**Ultimo Pyrmont Public School, 47 - 53 Jones Street, Ultimo (SSD 7503)
Notice of Exhibition**

Thank you for your letter dated 30 October 2017, requesting Transport for NSW (TfNSW) review and comment on the above.

Figure 20: Proposed vehicle access point, with Swept path of 9.5metre City of Sydney Garbage Truck entering / exiting the site

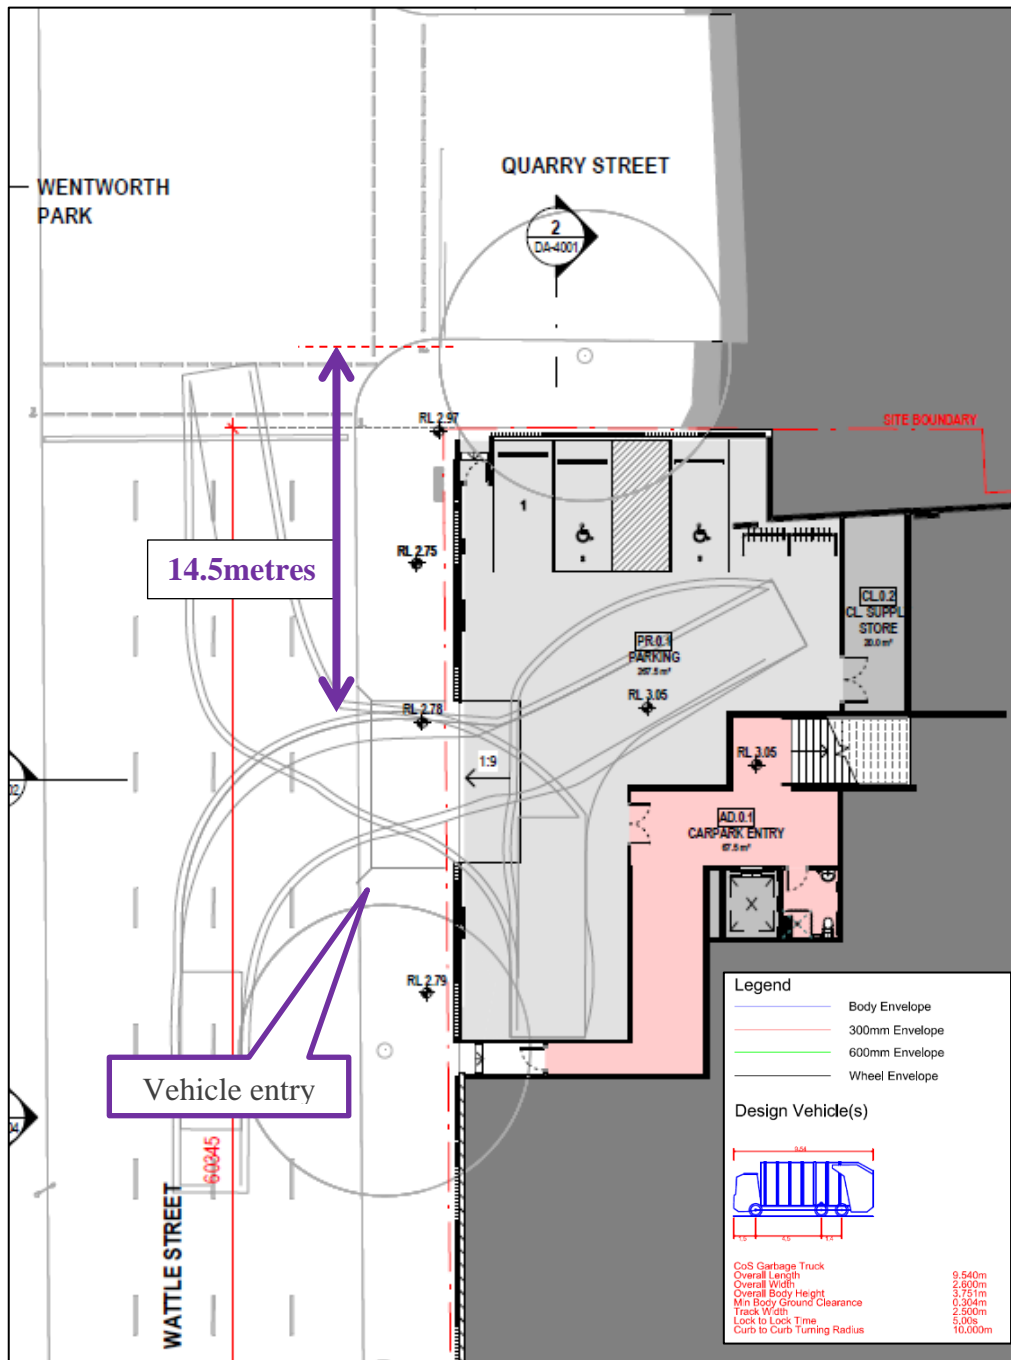
The following safety issues have been identified for the access arrangements to the school:

- The proposal includes reducing car parking provided on site and relocating the existing driveway closer to the signalised intersection of Wattle Street and Quarry Street. Wattle Street access to off-street parking and loading zone is located in close proximity to the signalised intersection of Wattle and Quarry Streets. Wattle Street is a Classified Road under the care and control of Roads & Maritime Services and any proposed changes to Wattle Street (including new and / or relocated driveways) would require concurrence from Roads and Maritime Services under the provisions of the Roads Act; and
- The swept path analysis shows that vehicles would need to straddle the two middle lanes to enter the site, which may impact on traffic flow and cause road safety issues for vehicles in Wattle Street.

TfNSW requests that the applicant amends the design of the driveway in consultation with the Sydney Coordination Office and Roads & Maritime Services to address these issues as part of the Response to Submissions and the final design for the driveway be endorsed by the Sydney Coordination Office and Roads & Maritime Services prior to the commencement of any work on site.

Figure 31: Proposed on-street parking adjustments

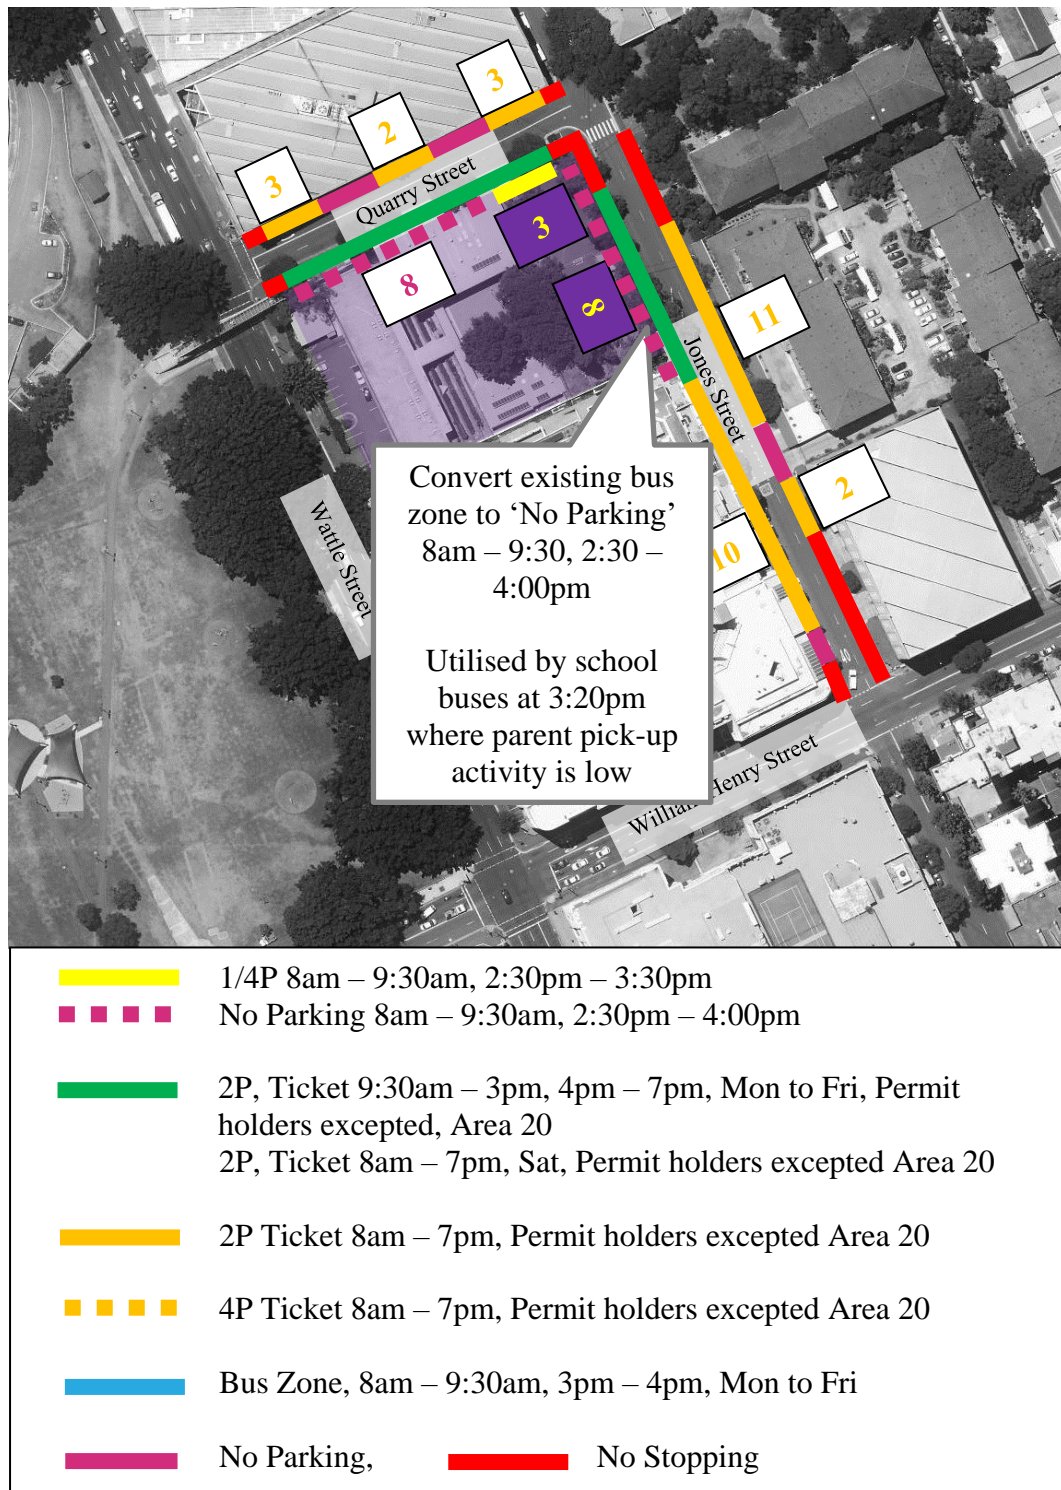
It is noted that the proposal indicates that the existing bus zone in Jones Street is proposed to be converted to a 'no-parking' zone to facilitate 'pick-up' and 'drop-off arrangements' with the existing school buses expected to wait until available space is available. It is advised that the proposed arrangement is not supported by TfNSW due to the following:

- Bus operations would need to be enhanced to facilitate/support transport for additional student numbers to the site;
- Potential conflicts between cars dropping/picking up students and buses accessing the 'no parking zone';
- A bus zone is required for school buses/coaches that transport students to sport/excursions/extracurricular activities; and
- Removal of the bus zone does not support sustainable transport to school and may result in an increase of general traffic in the area.

TfNSW does not support the removal of the bus zone and it is requested that alternative locations for vehicles dropping off and picking up children/ students be identified in consultation with the Sydney Coordination Office within TfNSW.

Figure A5: Swept path of 18.3 metre truck and dog entering the site from Wattle Street

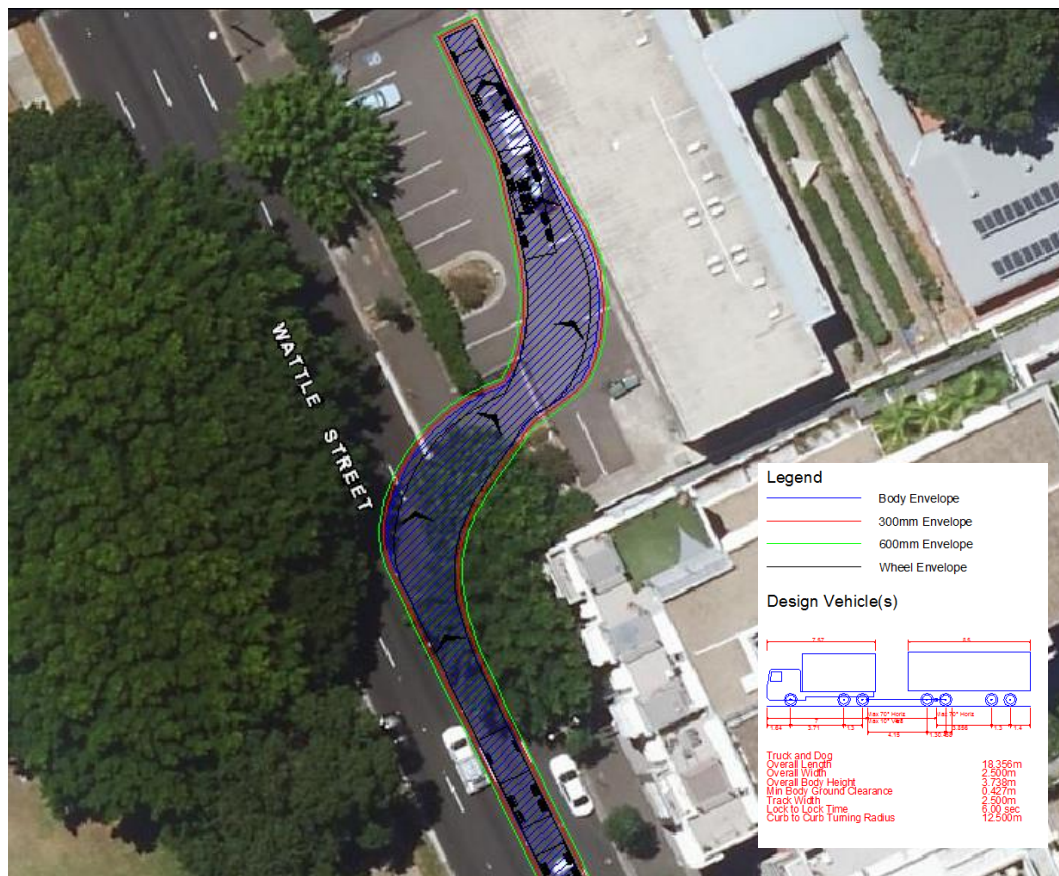
- Swept path of heavy vehicle exiting the site from Wattle Street should be provided. It should be noted that all vehicles should enter and exit in a forward direction;
- It is noted that any works zone established on Jones Street will have designated bus zone, however the draft CPTMP indicates that the existing bus zone as a potential works zone. This would only be possible outside of the hours the bus zone operates; and
- Wattle Street is a key traffic corridor and as a result, construction vehicle access, particularly for larger vehicles, may be restricted during the AM and PM peak periods.

It is requested that the applicant be conditioned to prepare a Construction Pedestrian and Traffic Management Plan (CPTMP), in consultation with the Sydney Coordination Office within TfNSW, with specific reference to but not limited to:
